***RE: CARQUEST WAREHOUSE ADDITION (D17-D35). GRADING AND DRAINAGE  
PLAN FOR FOUNDATION, BUILDING AND SO#19 PERMIT APPROVALS.  
ENGINEER'S STAMP DATED JUNE 7, 1999.***

***RE: CARQUEST WAREHOUSE ADDITION (D17-D35). ENGINEER'S CERTIFICATION  
FOR CERTIFICATE OF OCCUPANCY APPROVAL. ENGINEER'S STAMP DATED  
DECEMBER 27, 1999.***

RE: Traffic Circulation Layout Review for Building Permit  
Carquest Autoparts Warehouse Addition, 4001 Hawkins St. N.E. (Stamp not dated)

C-1

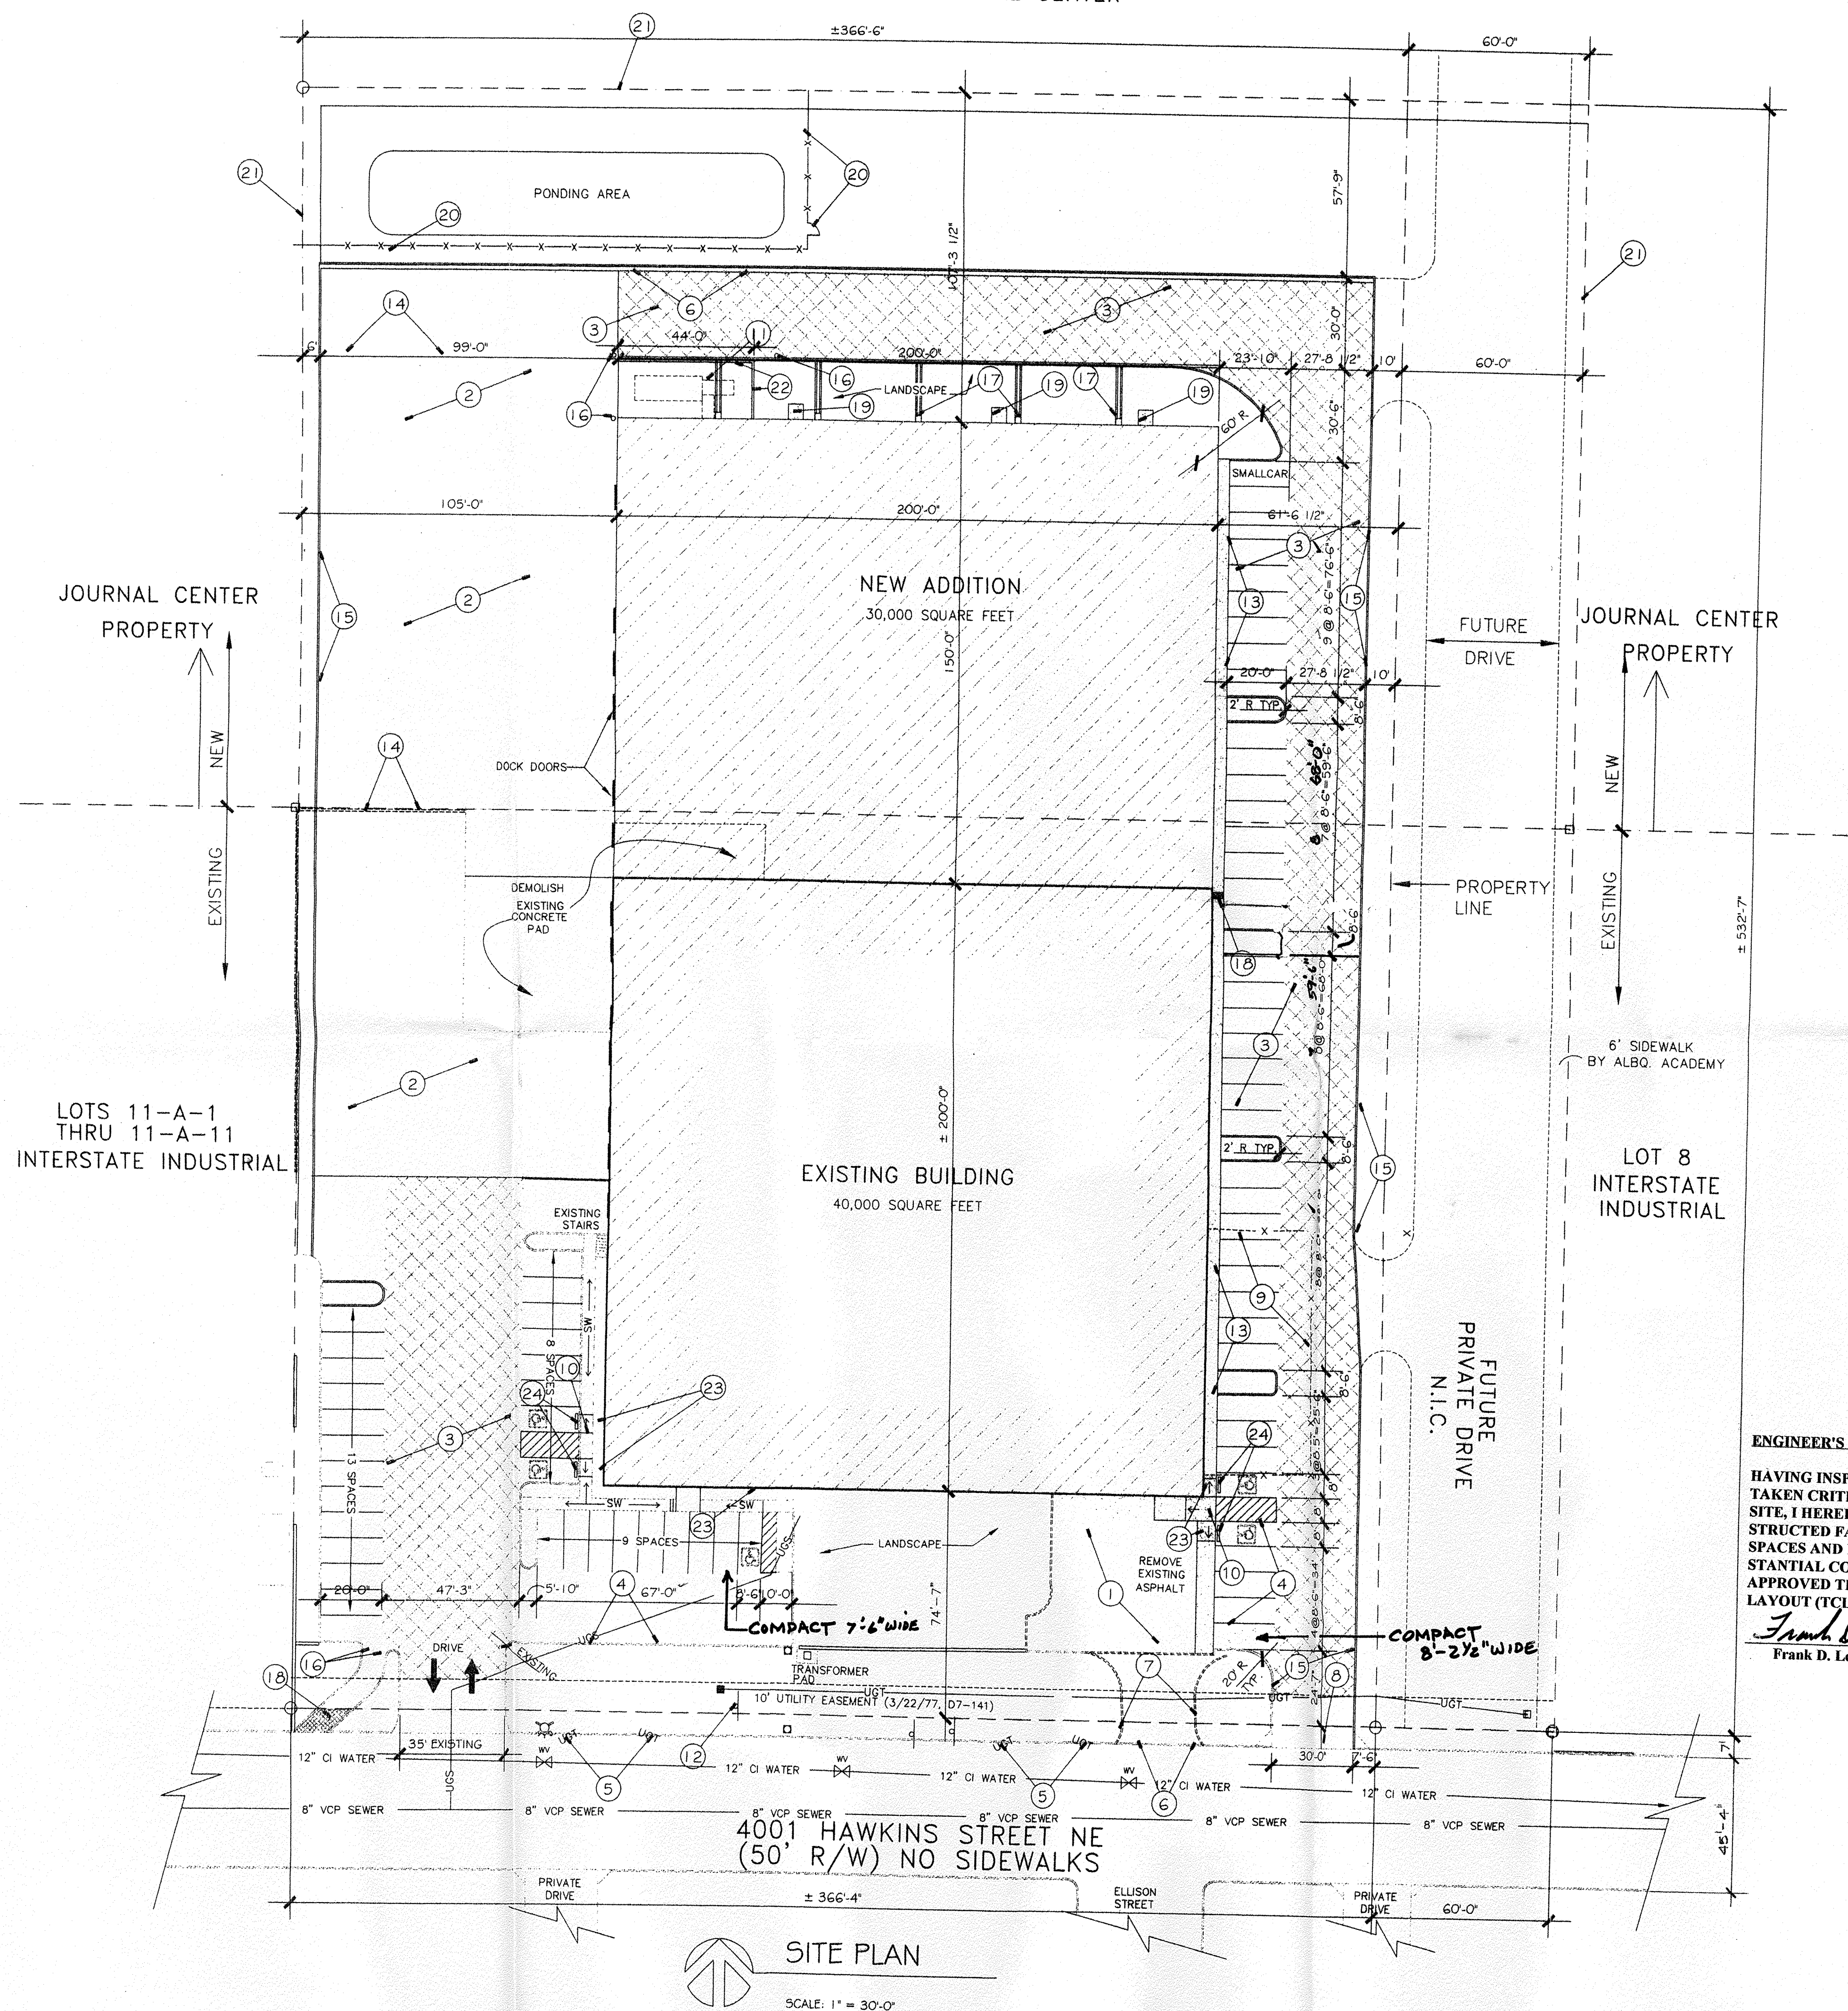
The above referenced Traffic Circulation Layout (TCL) requires modifications to the site plan prior to review for Building Permit.

The comments are indicated in red ink on the attached marked-up site plan. More information is needed on the site plan in regards to the usage of the concrete paved areas. It is not clear that if there will be any vehicular traffic in those areas. The width of the isles and drive ways depends on the maximum size of trucks using this facility. More detail is needed for the isles and driveways.
